439-C-14

Apt. Addition

90 Chesley Ave.

RE: Application for Apartment Addition at 90 Chesley Avenue (App.# 2006-0054)

PROPOSED APARTMENT ADDITION PLAN
 90 CHESLEY AVENUE PORTLAND, MAINE
 FOR: **GERALDINE DONGO**

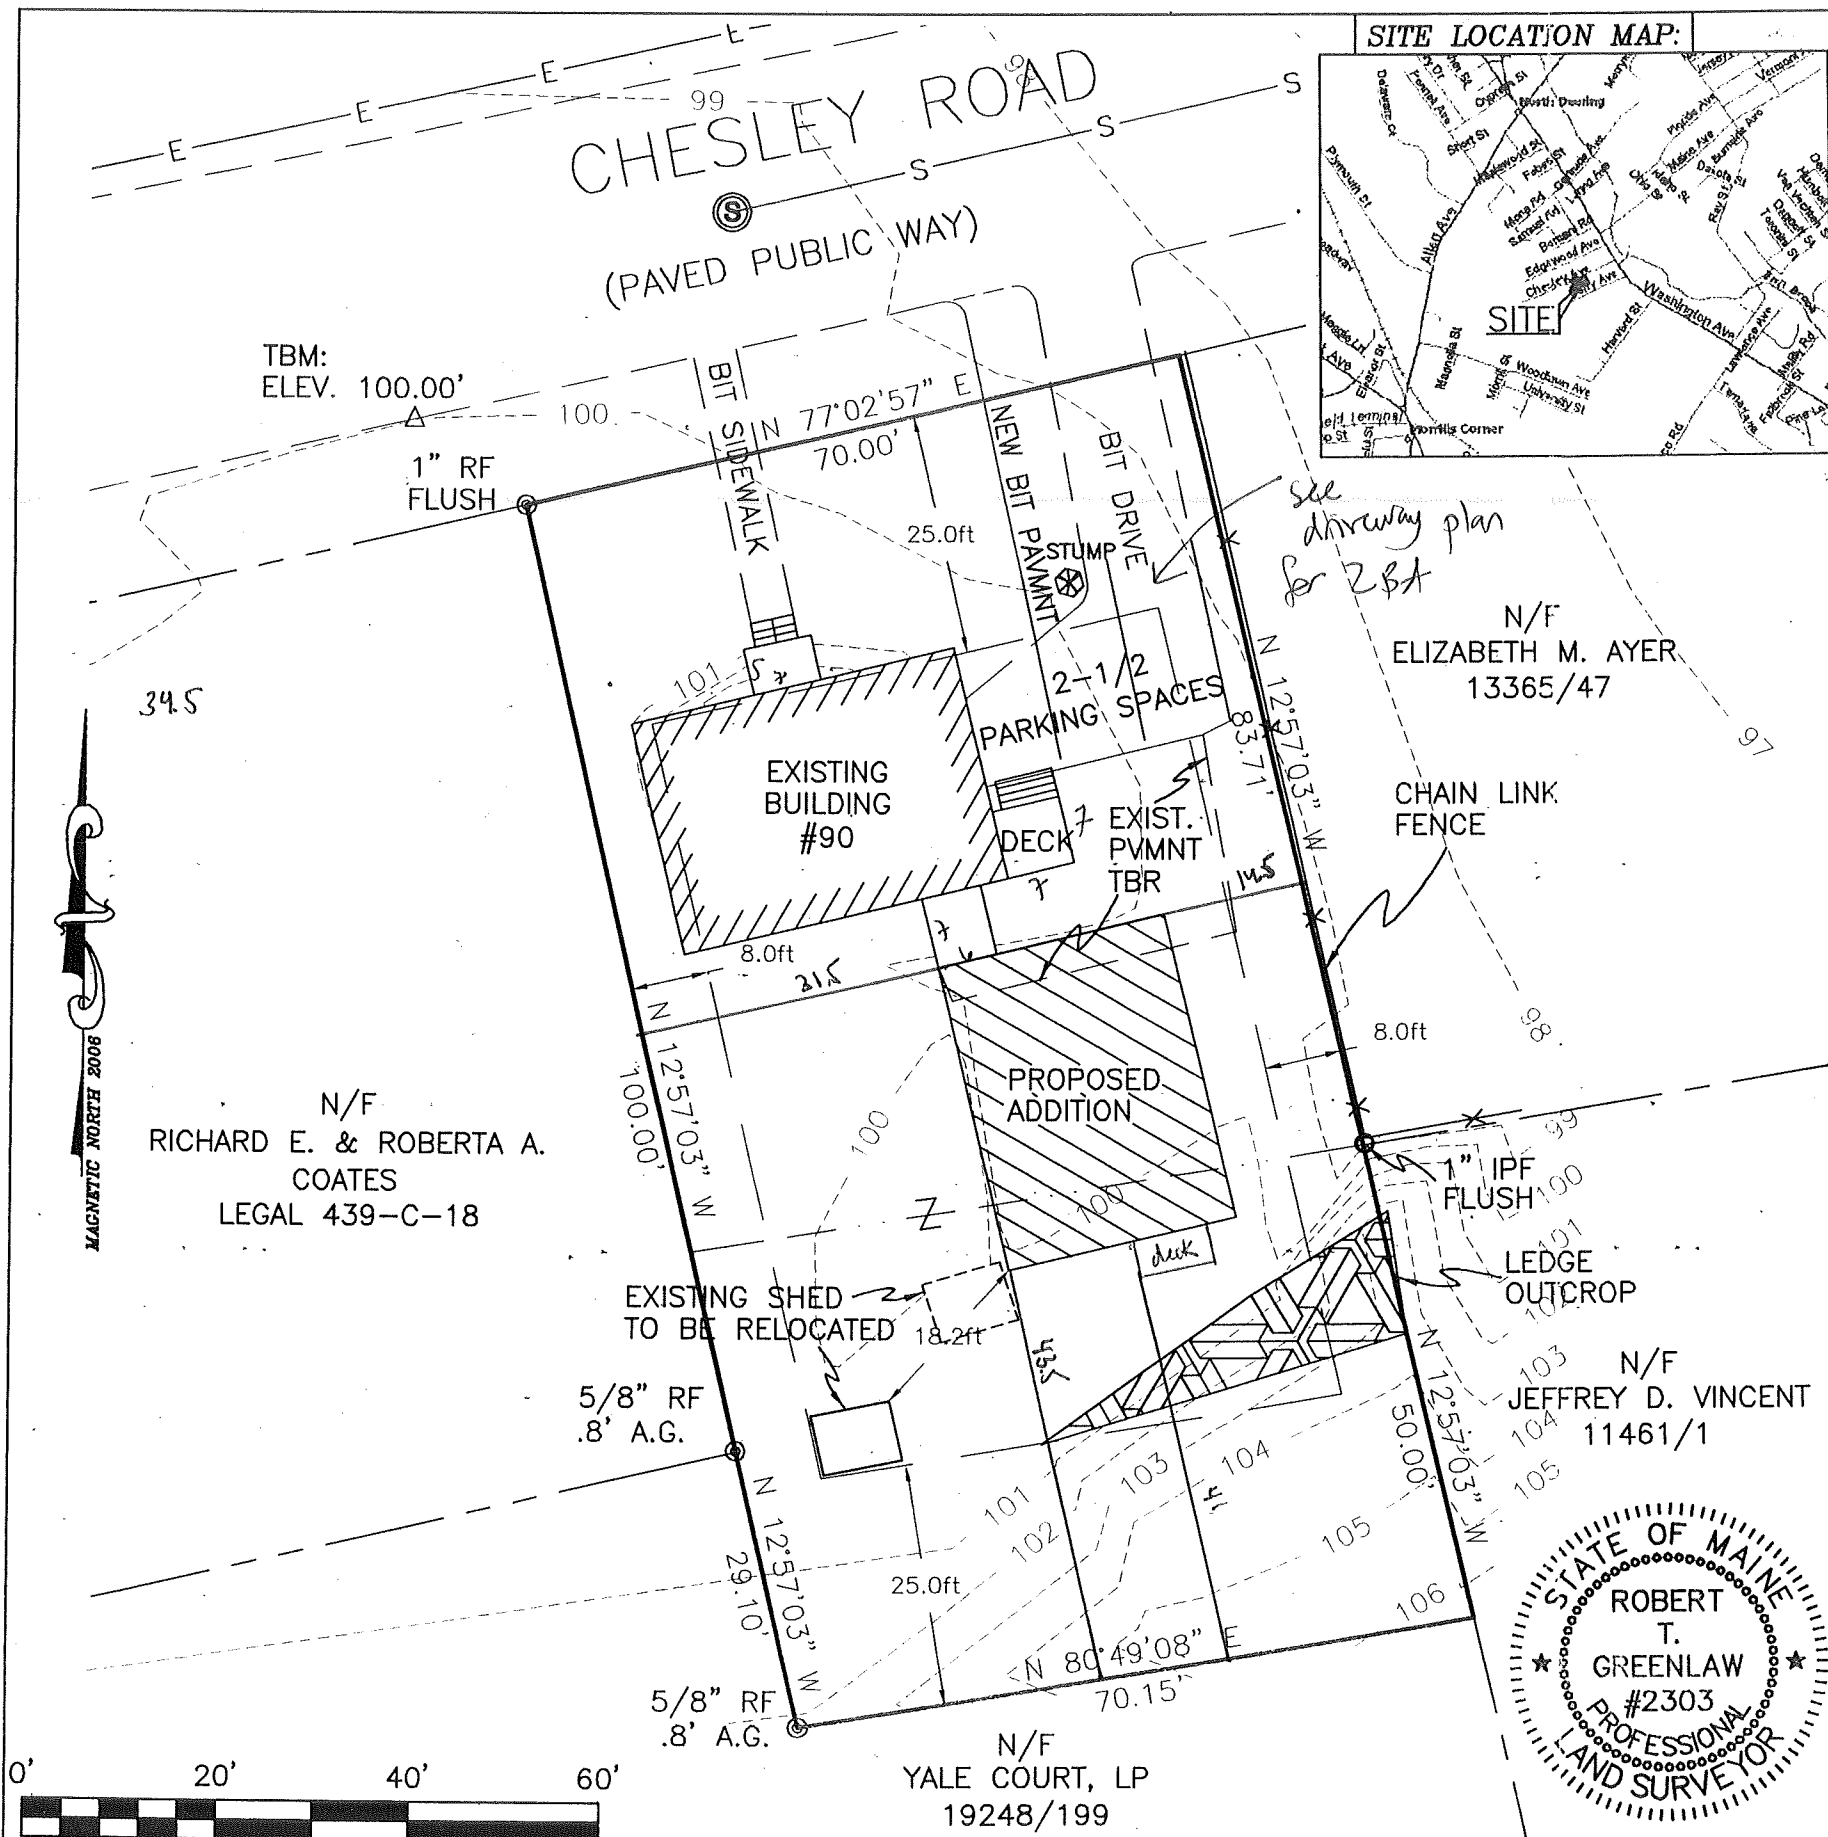
1. Please modify the site plan to have 1 additional parking space. Per zoning requirements, this space must fall outside of the front setback and in the r-3 zone must be a minimum of 5 feet from the side/rear property line. *Does*

2. Please show the proposed utilities, if any. Where ~~is~~ the foundation drain connect or outlet?
3. The site plan shows no change in topography. Due to the increase in impervious surface (building and pavement), some method of managing the stormwater flows is required. In particular, how will drainage not negatively impact the neighboring property (Ayer)?

4. Indicate whether any exterior lighting is proposed with this application.
5. While construction is occurring, erosion control measures must be implemented. Please add to the site plan where appropriate.

6. Due to the proximity to the neighboring property, it is recommended that additional landscaping be added along the easterly side boundary line. Please add to the plan. Also, for single family development, two 'street trees' are required to be installed along your road frontage. Please add to the plan.
